November 17, 2022

Gareth Reece  
Senior Plans Examiner  
City of Mercer Island Community Planning and Development

RE: Permit 2109-150 SUB2 Correction Comment Responses  
Site Address: 9611 SE 72<sup>nd</sup> Street

A101

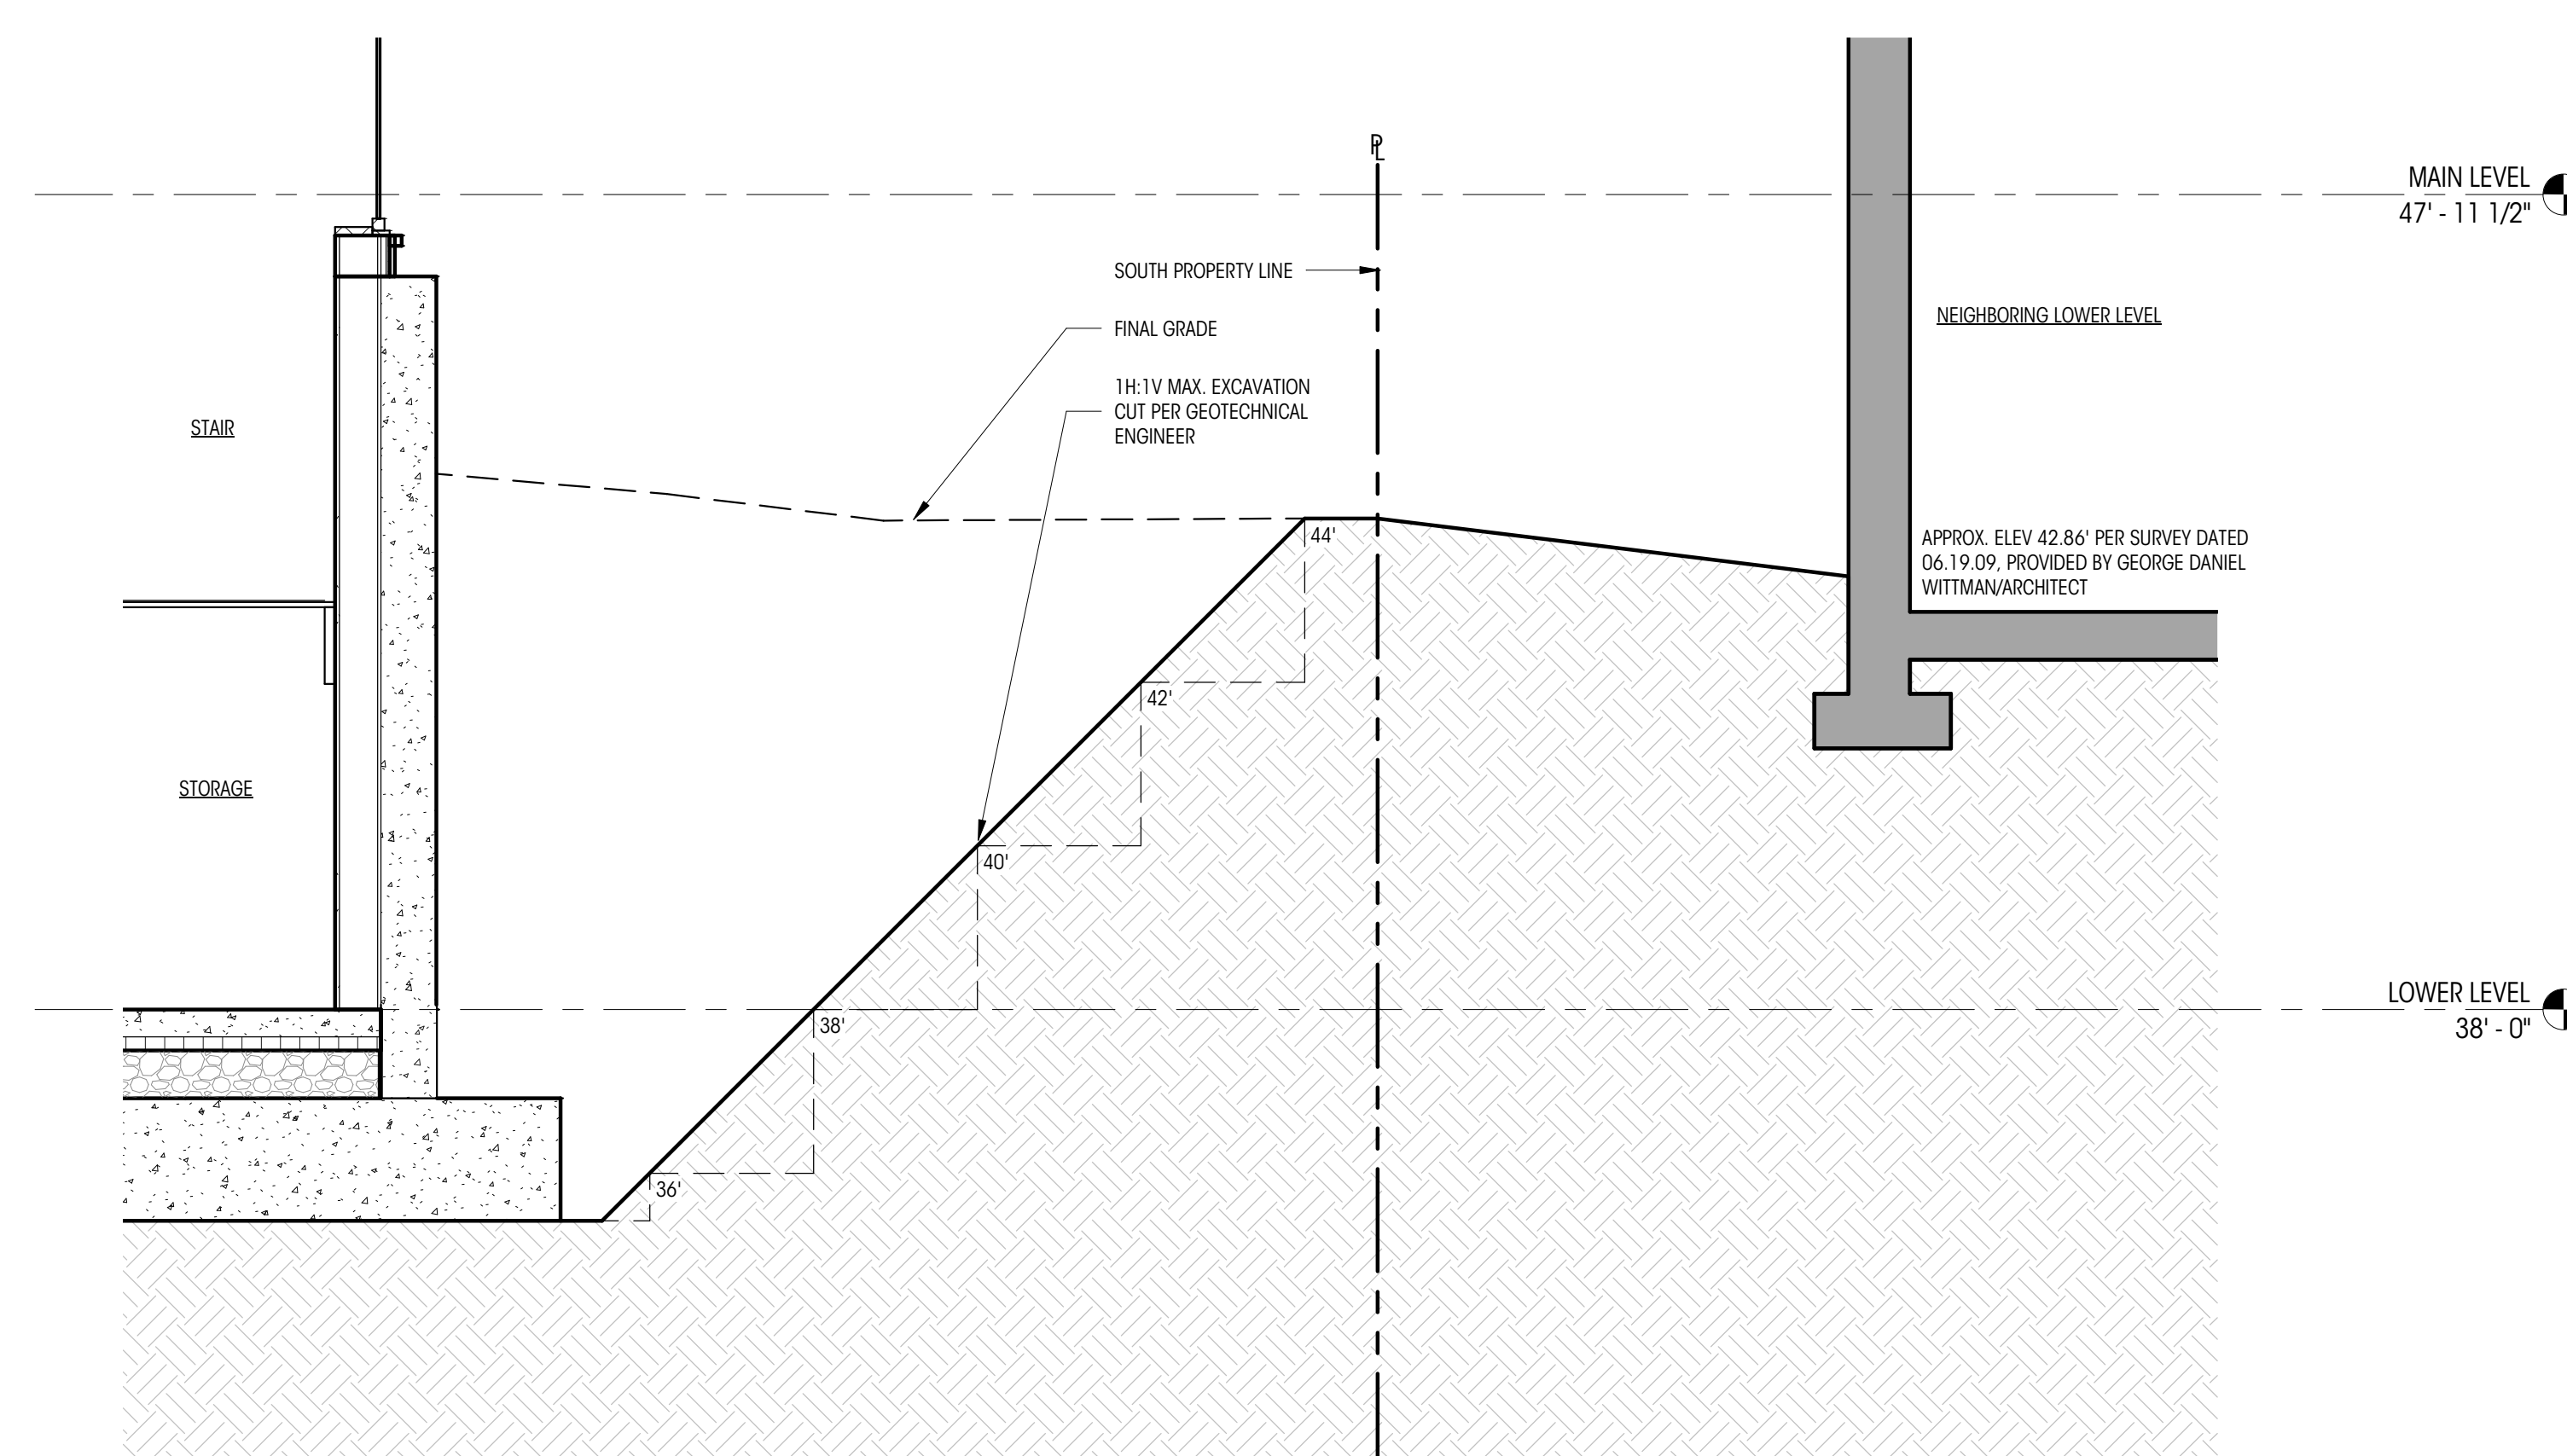
4. Page 3 of the January 6, 2022, PanGeo addendum letter indicates that 2 or 3 soldier piles should be added to the south side of the excavation for the garage. We do not find this incorporated into the design; see Sheet SH2.1.

structural engineers. We have confirmed with PanGeo that shoring is not required on the south side of the subject site. Please refer to the submitted addendum and site sections on Sheet A101 showing that a 1H:1V temporary cut slope can be achieved within the property boundary of the subject site. Michele Lorilla noted via email on 05/24/22 that this resolves the correction comment.
